# Rezoning Transportation Analysis

Petition Number: Petition #2022-045

## Revision Log:

Date	Description
08-11-2022	First Review (WB)

RZ-2

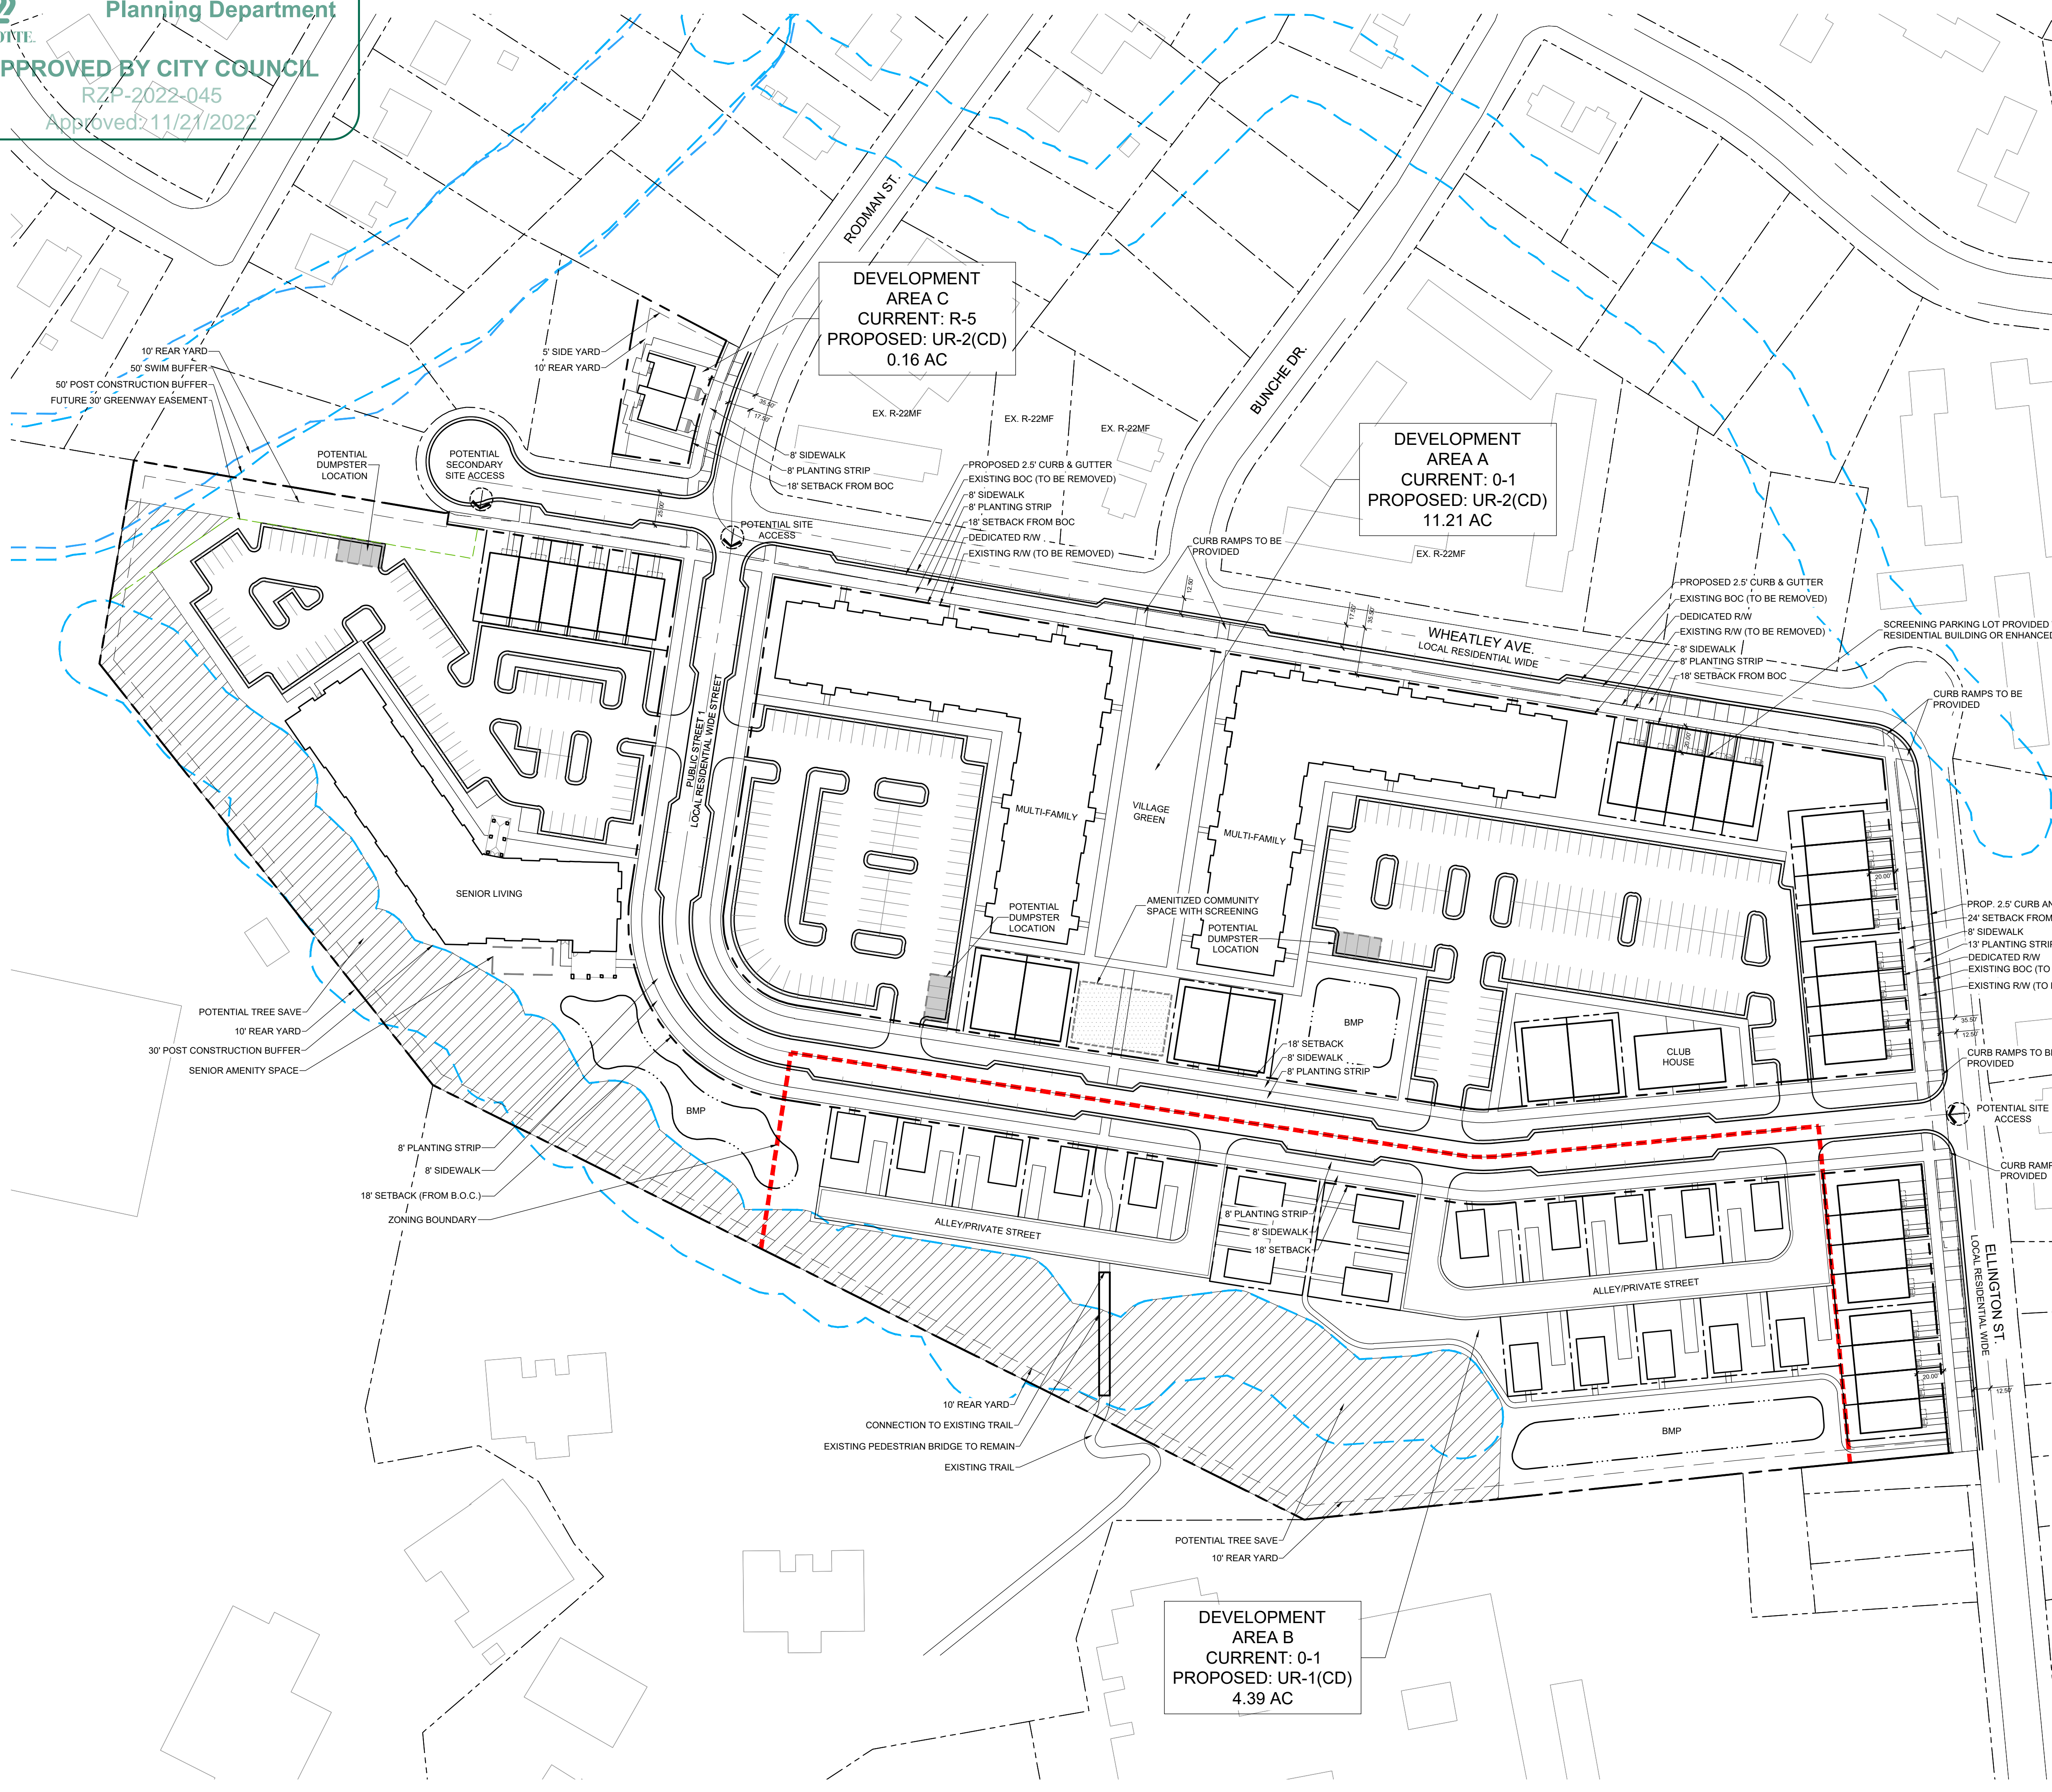
1. **Curblines:** The proposed zoning district has a setback measured from back of the existing or proposed future curblines.
  - a. **Wheatley Avenue:** The curb and gutter needs to be constructed 20.5-ft from the road centerline.
  - b. **Ellington Street:** The curb and gutter needs to be constructed 20.5-ft from the road centerline.

Label and dimension the curb and gutter from the centerline for each road on the site plan.

3. Revise site plan and conditional notes to commit to dedicate 28.5-ft right-of-way from each public road centerline. The site plan shall label and dimension the right-of-way from each road centerline.
4. Site plan and conditional notes revisions are needed to remove proposed access points off Ellington Street and to accommodate alley-fed townhomes within the site.

5. Revise site plan and conditional notes to construct curb ramps to provide accessibility per PROWAG and ADA law.
